Re: White Barn Dental – PA22-029 – Technical Review 1
8833 Soper Hill Rd

After review of the preliminary Site Plan Review, the Planning Division has the following comments:

RE: White Barn Dental, File# PA22-029
New Dental Office
8833 Soper Hill Rd & Parcel # 00590700031800

To: Emily Morgan, Senior Planner
From: Don McGhee, Assistant Fire Marshal
Date: July 15, 2022
Subject: PA22-029 White Barn Dental Office Building 8833 Soper Hill Road

TITANIUM OFFICE, LLC
DENTAL OFFICE - WHITE BARN
PRELIMINARY SITE PLAN

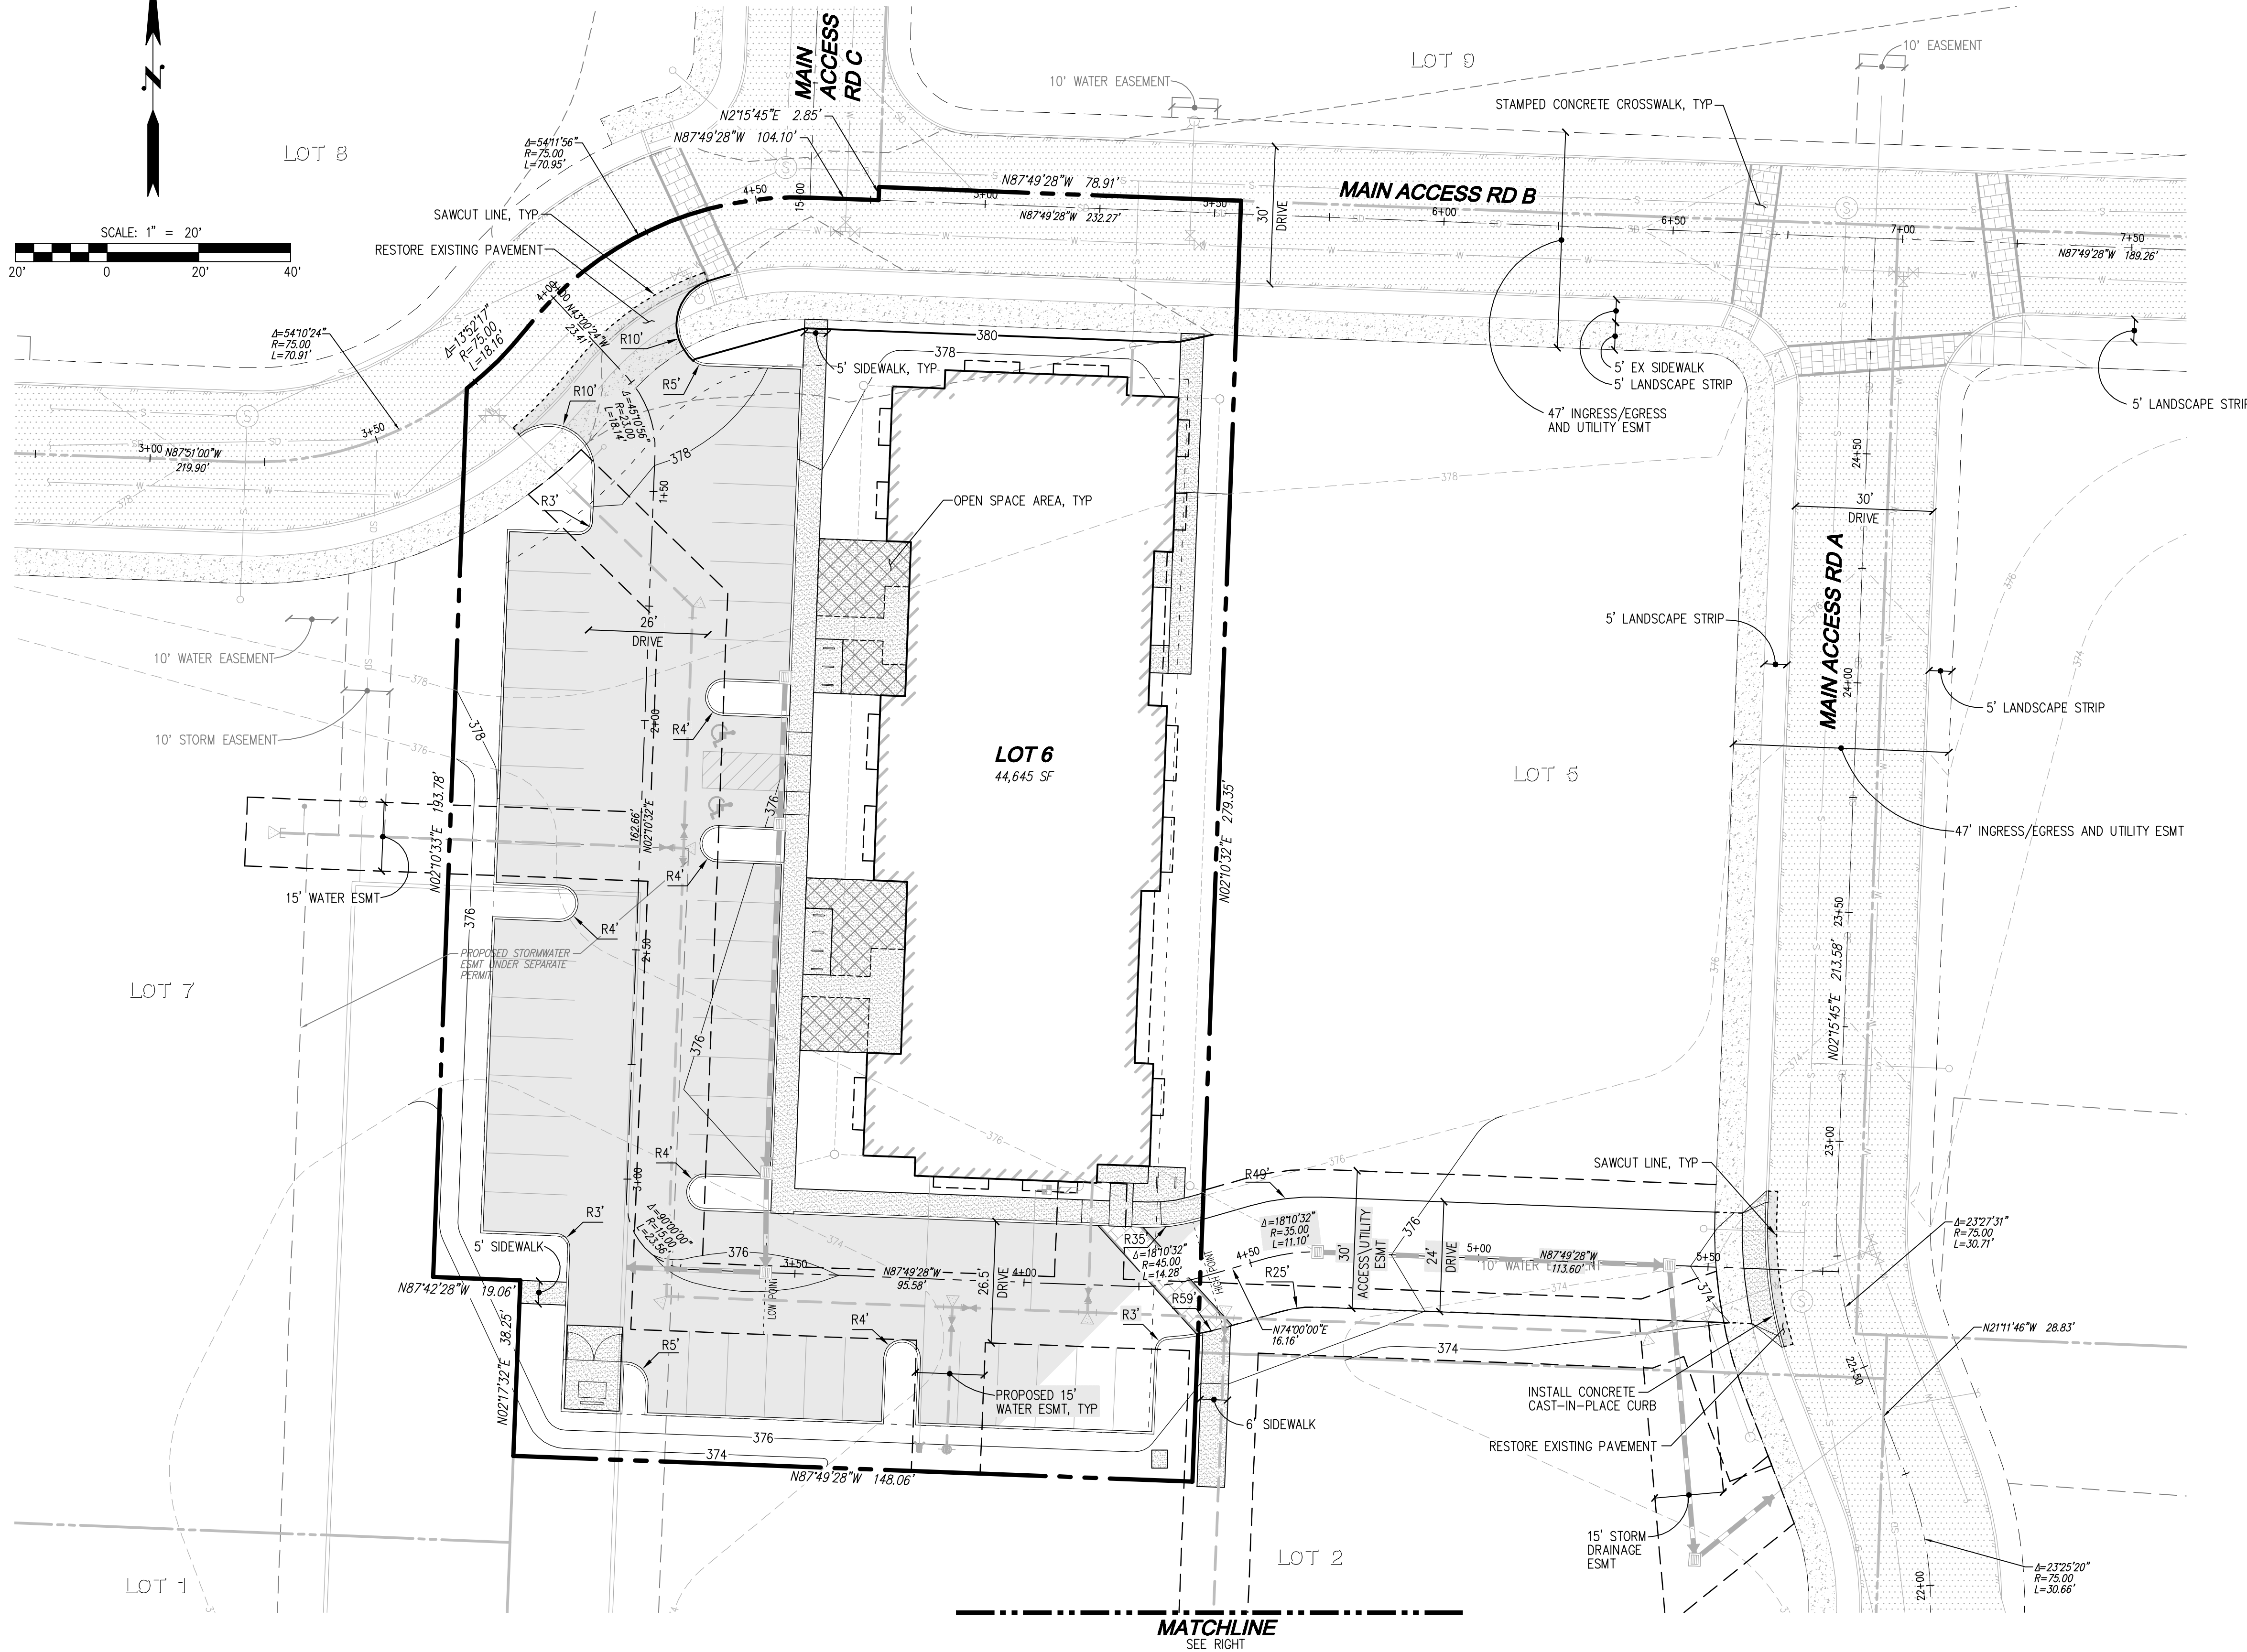
3. Based on the Commercial Business (CB-WR) zoning within the ESWR, the maximum impervious surface allowed is 85% of the lot; this figure was not demonstrated in the application materials. Revise site plan to show this calculation.

However, the provided Project Narrative and Site Plan appear to have different figures for the number of parking spaces required and proposed. Revise to clarify what is being provided, including bicycle parking.

TITANIUM OFFICE, LLC
DENTAL OFFICE - WHITE BARN
 PRELIMINARY ROAD AND UTILITY PLAN

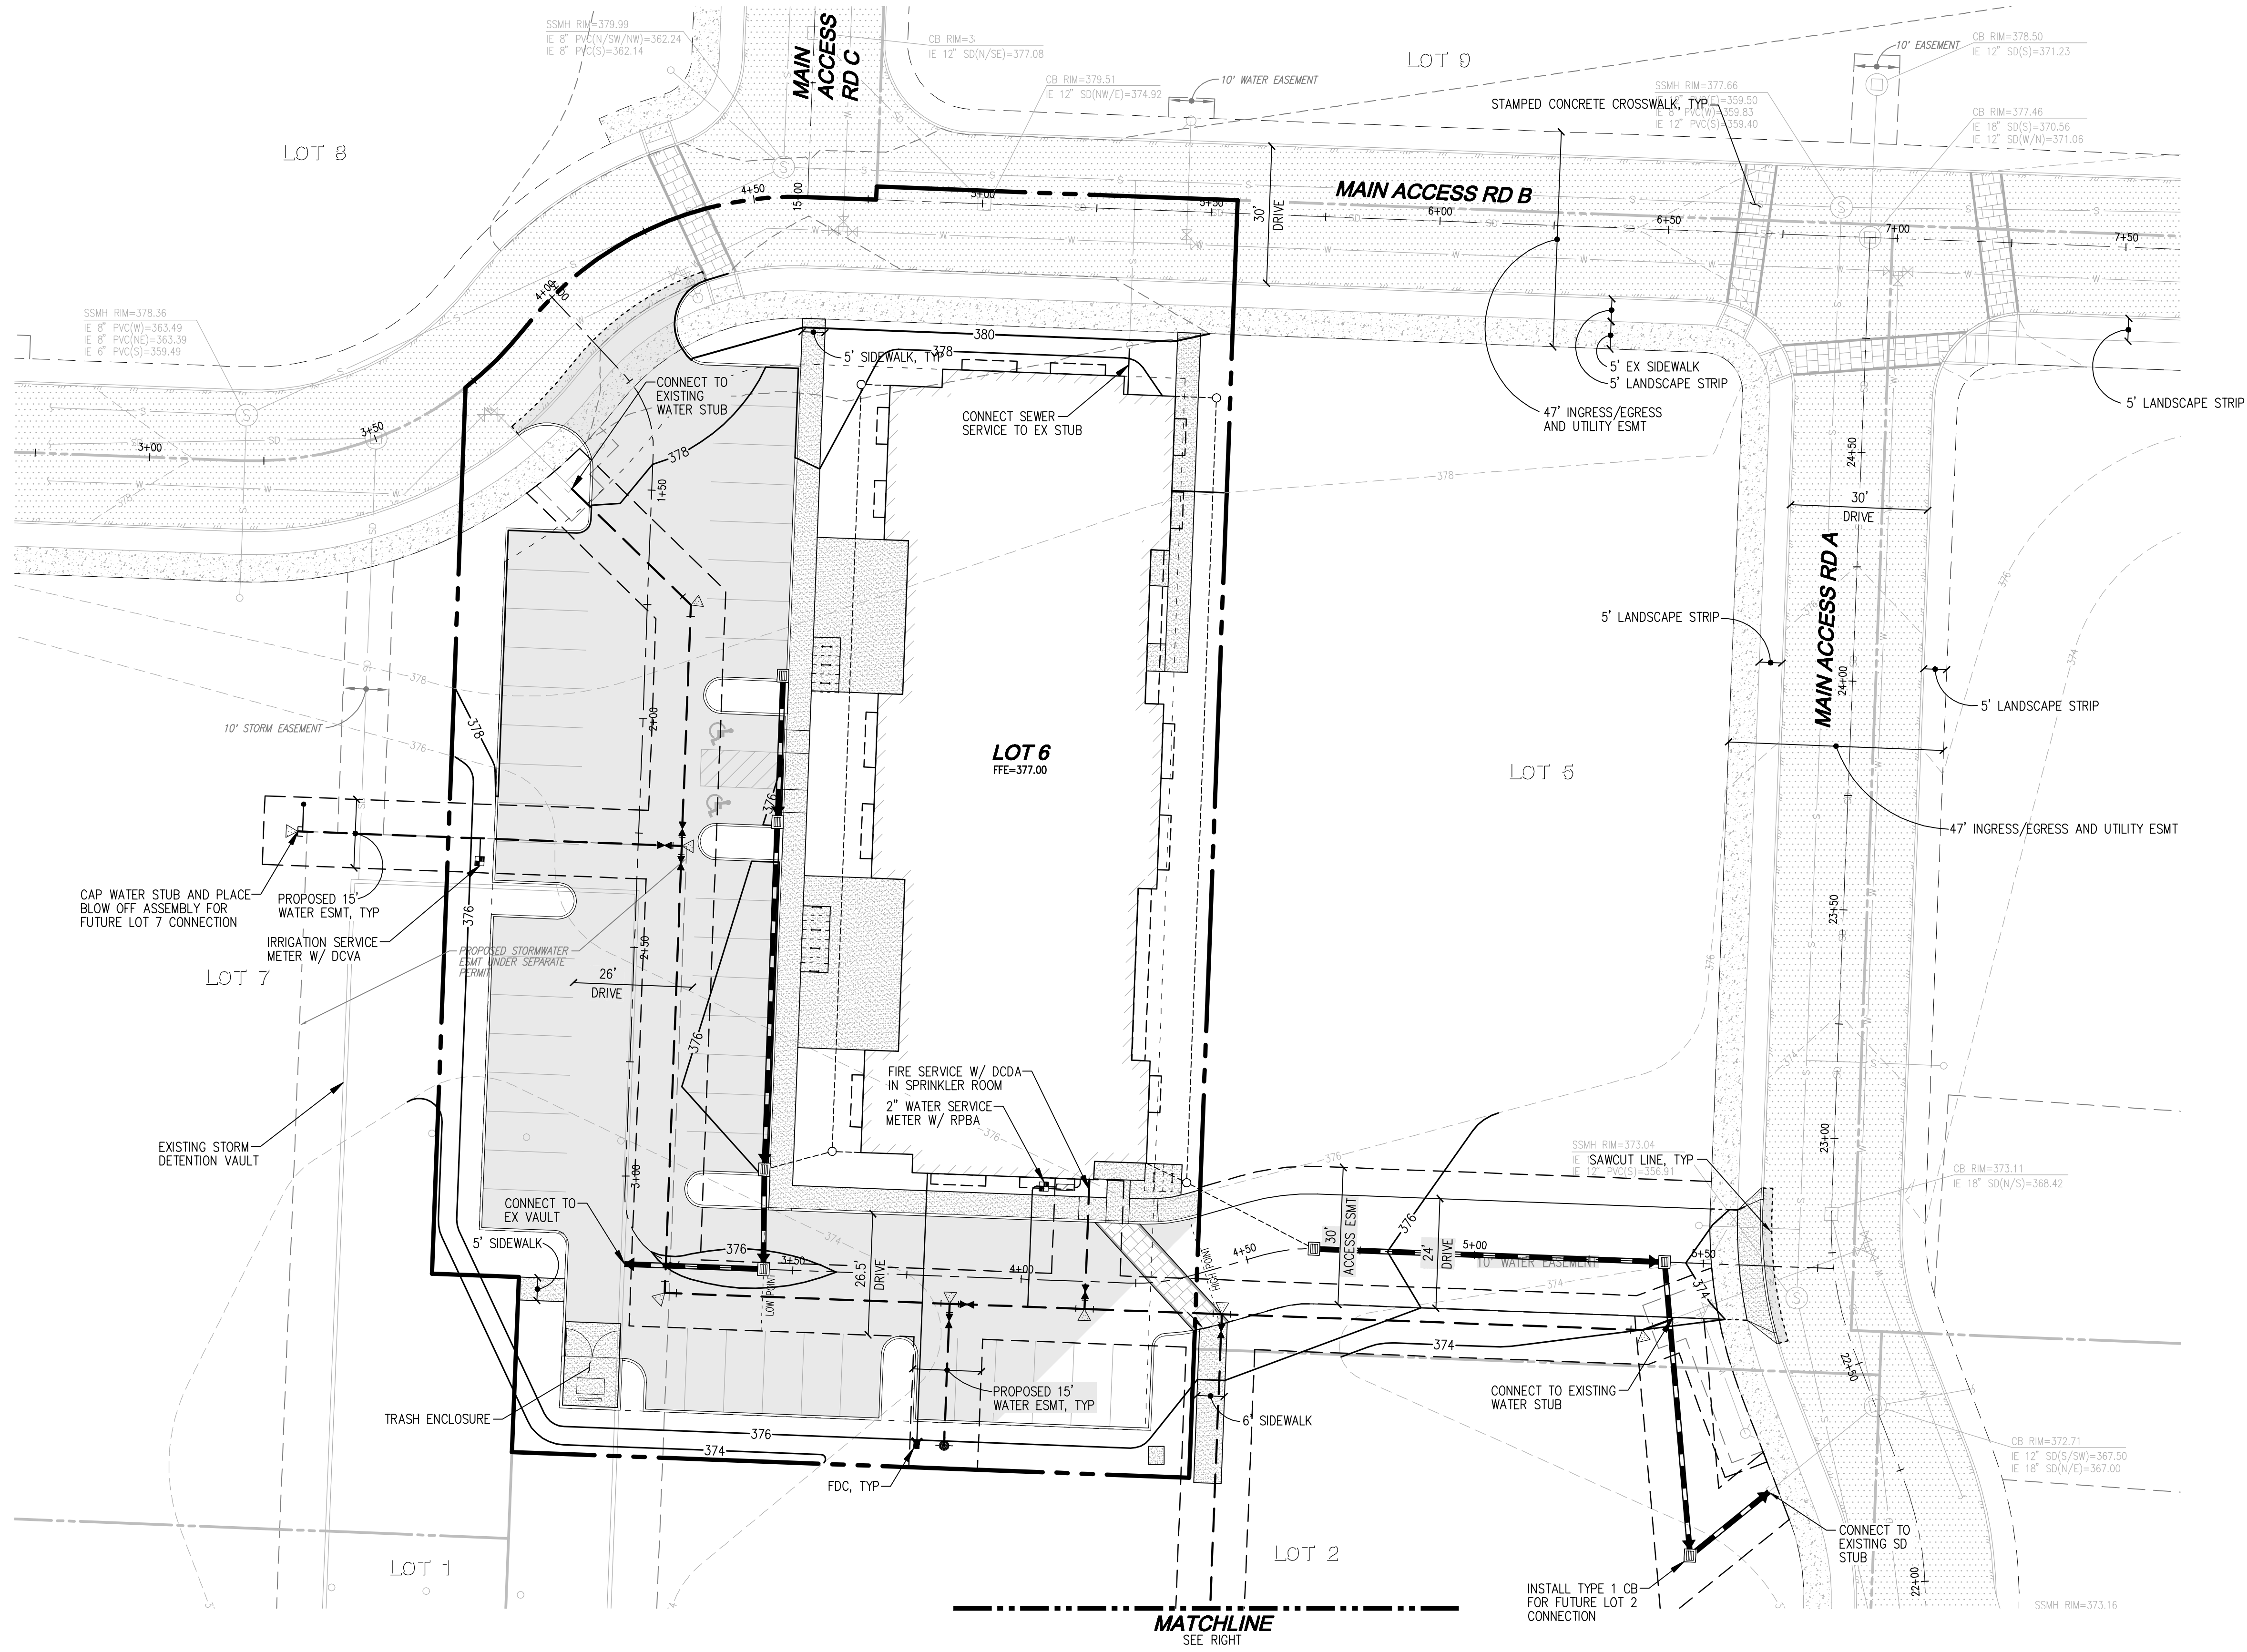
1. Future connection for lot 7: Blow off assembly needs to be at end of pipe section;
2. Is there need for irrigation of landscaping? If so, irrigation meter and appropriate backflow prevention needs to be shown;
3. Water details not shown within provided plan set;
4. Add temporary blow off to fire service stub for lot 2 like lot 7.
